Longfield Solar Farm

Statement of Common Ground – Environment Agency

PINS Reference: EN010118

Document Reference: EN010118/EX/8.4(A)

Figure 3 : SFRA Fluvial Flood Zone Mapping 65% Climate Change - Fluvial Modelling Report

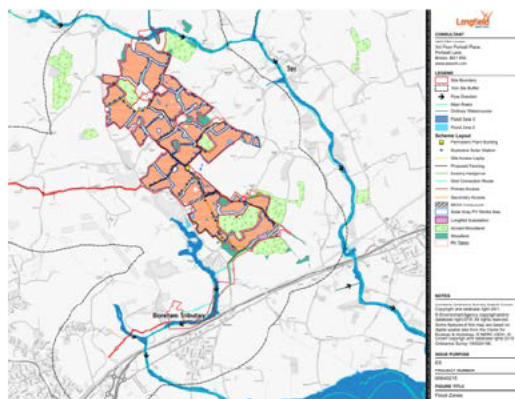
12	Development areas and Flood Zones	Appendix A of the FRA shows the layout of the development. It should also have a map showing built development in relation to the flood zones (including climate change, for the lifetime of development and beyond, as a sensitivity test). [Statutory consultation]	The updated FRA is available in Appendix 9A Flood Risk Assessment [EN010118/APP/6.2] . Figure 3 shows areas where above ground development may be located in relation to Flood Zones.	Agreed
